From: Oram, Richard - Communities <Richard.Oram@Oxfordshire.gov.uk>
Sent: 12 October 2021 09:11
To: Planning
Cc: Planning Consultations - E&E
Subject: 21/02591/DISC - South Of Salt Way Banbury

The applicant has submitted an updated post excavation assessment. This assessment has addressed a number of our previous comments. It does however now omit any of the section drawings included in the earlier draft versions. These will need to be added.

Figure 8: Inhumation burial 472

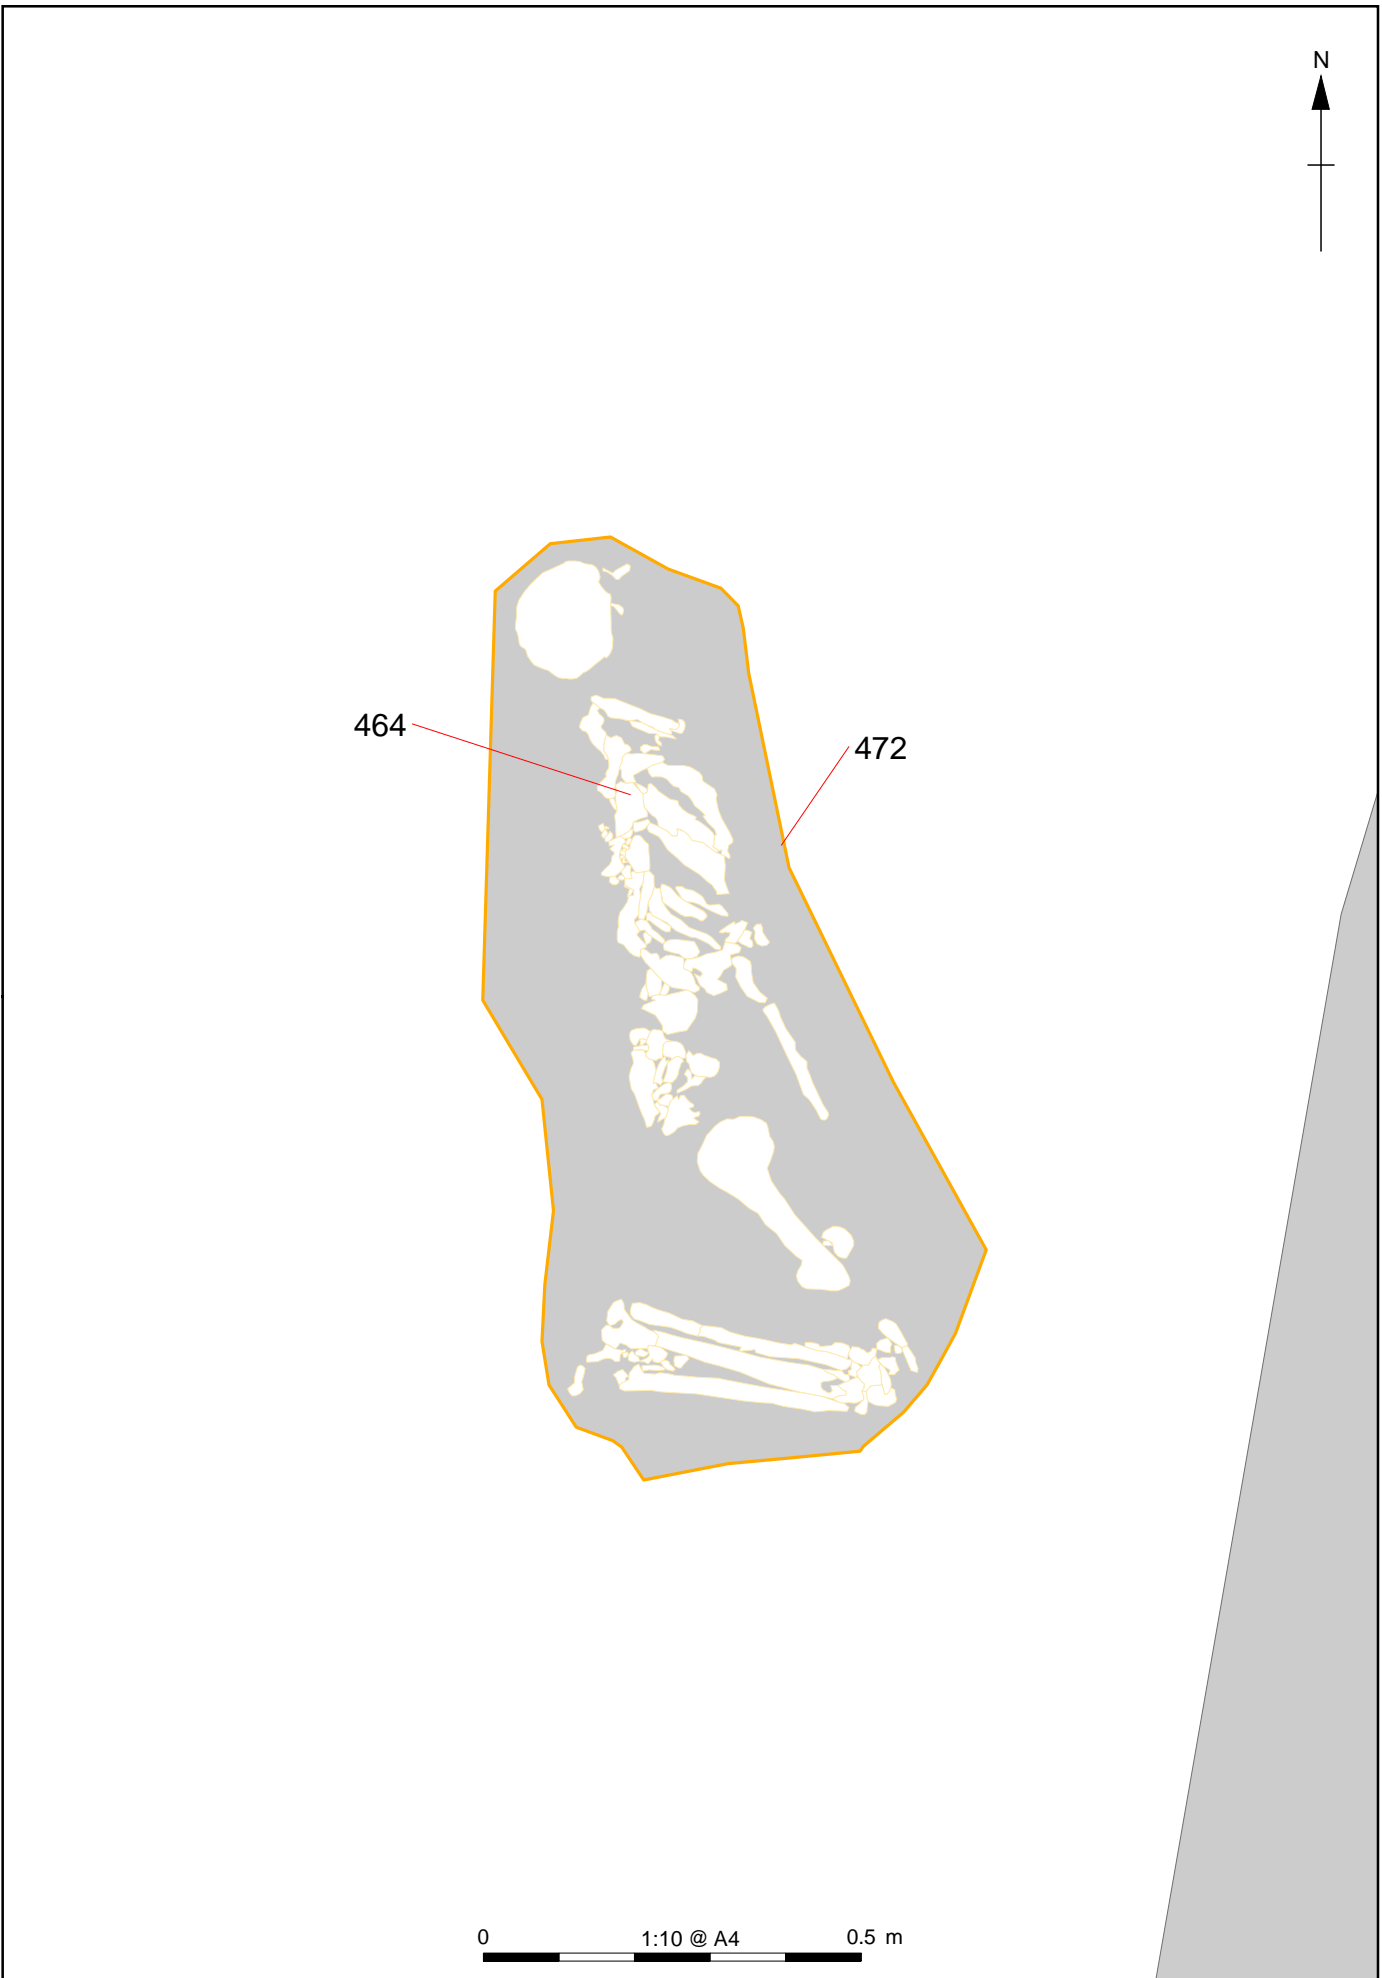
We had also previously requested that further details of the burial, particularly a plan, be included. we have emailed the archaeological consultant about these matters and a further revised copy of the assessment is likely to be submitted for our agreement. It would be beneficial for the applicant to wait until this post excavation assessment has been agreed before submitting it for planning purposes.
